Your ref: TR010029
Our ref: M25 J28/PINS/05

M25 junction 28 improvement scheme
Development Consent Order application reference: TR010029

Notification of intention to make a request for changes to the Scheme

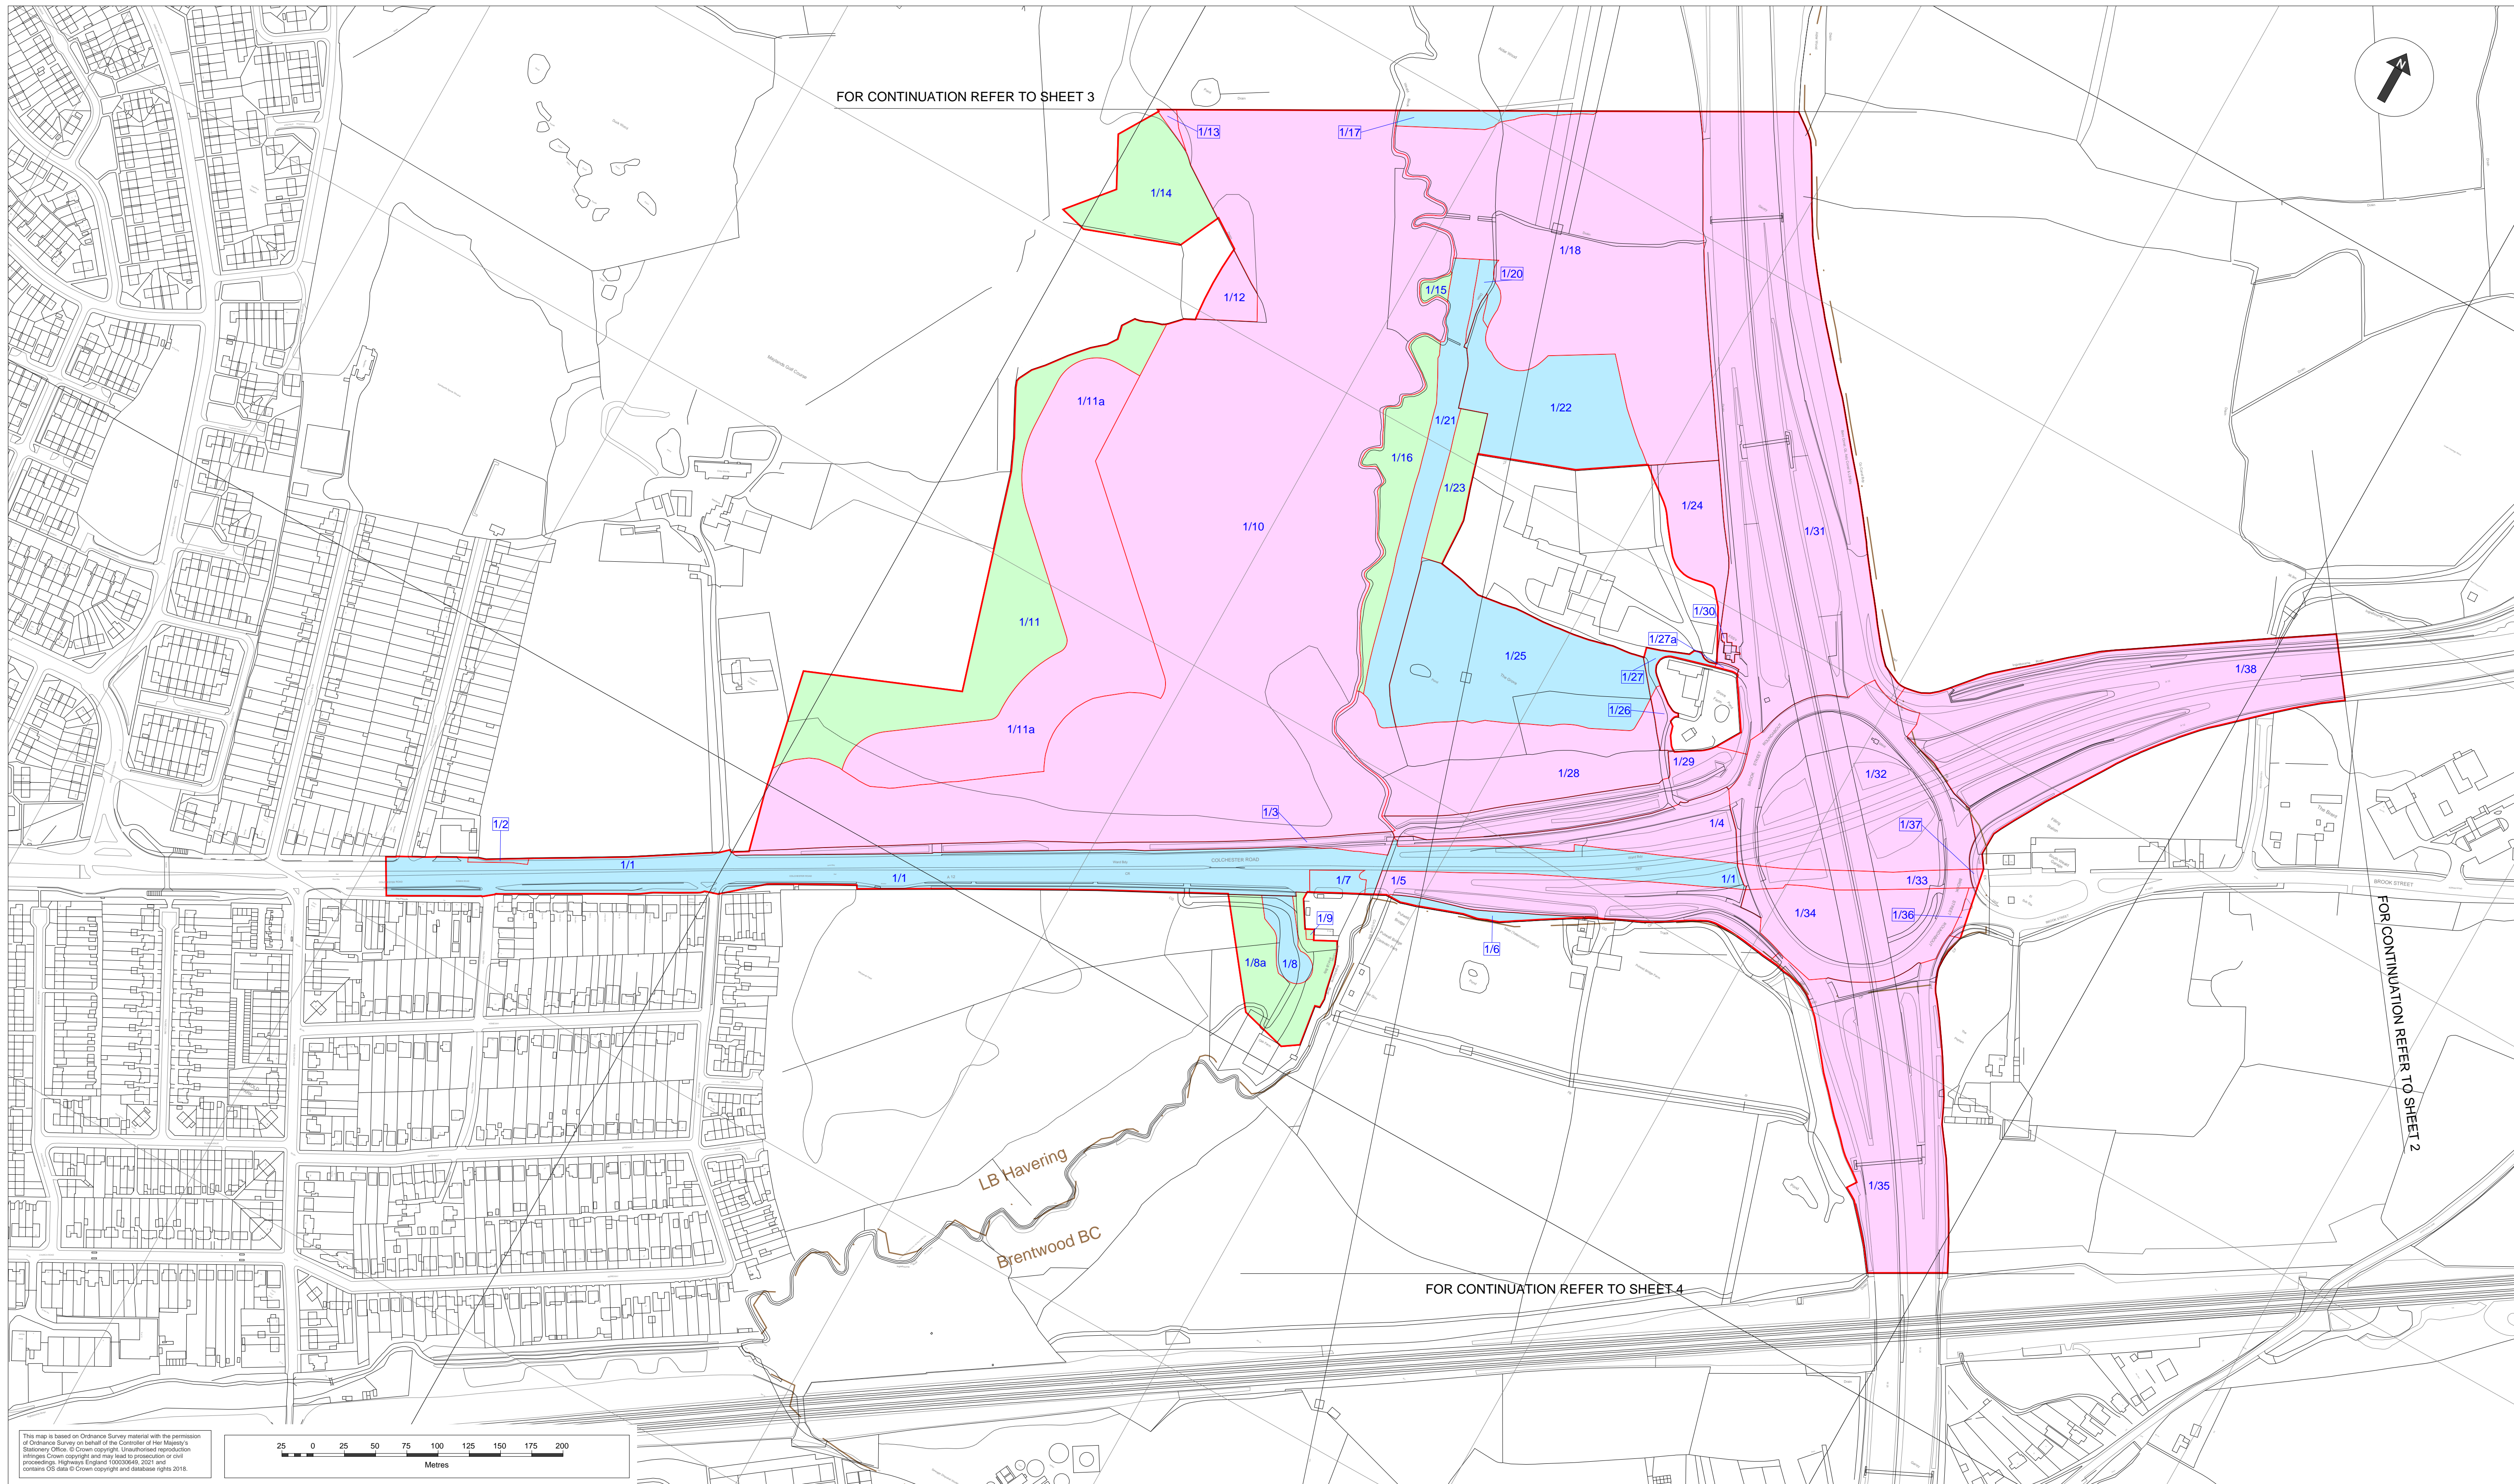
Were this change to be accepted, the permanent acquisition of part of plot 1/11 (Sheet 1 of the Land Plans (APP-005)) will be required. Currently the application seeks temporary possession of plot 1/11 to facilitate and enable the construction of the Scheme. However permanent acquisition of land will be required to enable the long term maintenance of the environmental bund which is to form Work No. 18. As this change would require additional compulsory acquisition powers for plot 1/11 the Infrastructure Planning (Compulsory Acquisition) Regulations 2010 (the **2010 Regulations**) are engaged. Accordingly, Highways England will be seeking to obtain consent from persons with an interest in plot 1/11 to the inclusion of such powers within the application under Regulation 4 of the 2010 Regulations or will follow the prescribed procedure contained in Regulation 5 to 19 of the 2010 Regulations if the consent of the land interests is not obtained.

**PROPOSED CROSS-SECTION OF ENVIRONMENTAL BUND**  
**SECTION P-P**

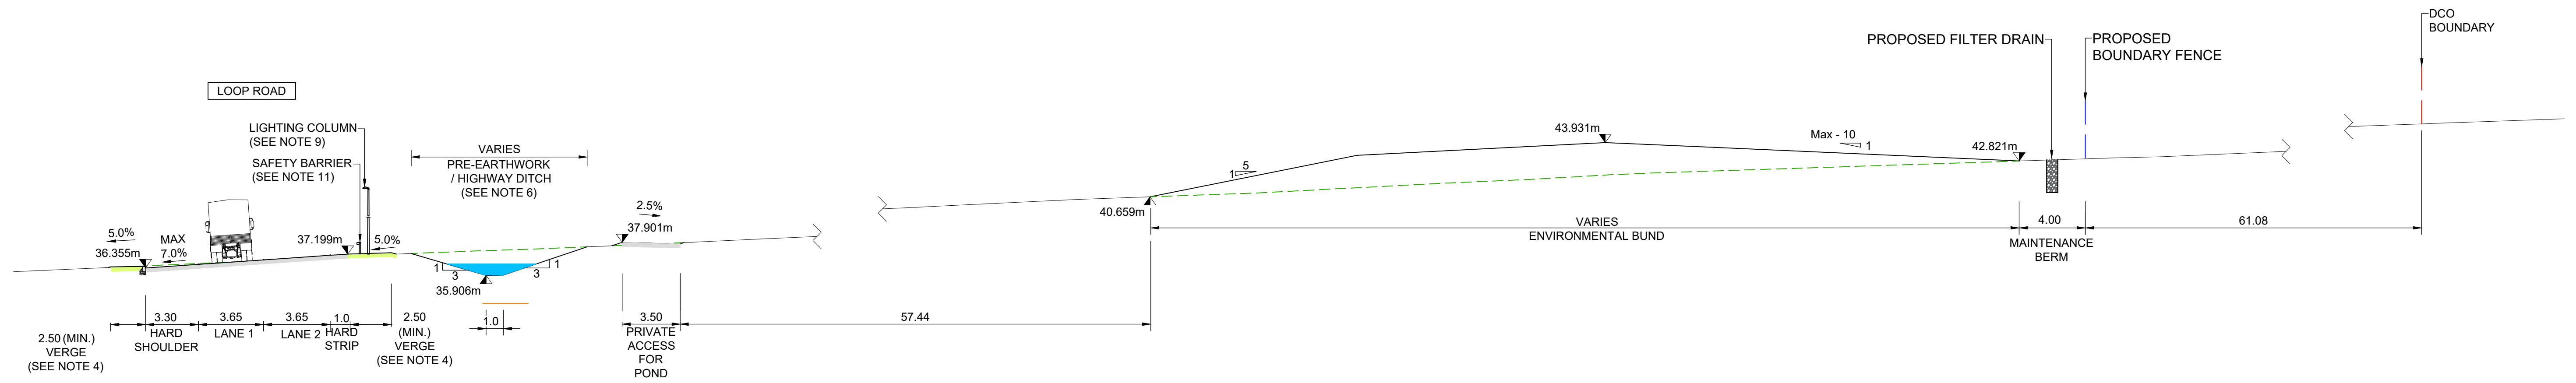
Change 2 – Amendment to the surplus construction materials deposit (Work No. 18) situated to the north of Work No. 19B to form an environmental bund

This change is also proposed in response to submissions made by the EA in its Relevant Representation (RR-009) raising concerns in relation to the reuse of site won material on site. Following further engagement with the EA, and acknowledging representations made by others (including the operators and lessees of Maylands Golf Course (Luddington Golf Course Limited) and the residents of Woodstock Avenue), it is proposed to remodel Work No.18. Work No.18 would be remodelled into an environmental bund which follows the outline of the environmental works (part of Work No. 25) alongside the new loop road and to the north of Work No. 19B. The beneficial reuse of site won material within the environmental bund will provide visual and noise screening to residents at Maylands Cottages and Woodstock Avenue, as well as to Maylands Golf Course.

The engineering drawings and sections for Work. No.18 will be updated to demonstrate the new height of the environmental bund which is proposed to be 2.5 metres high.
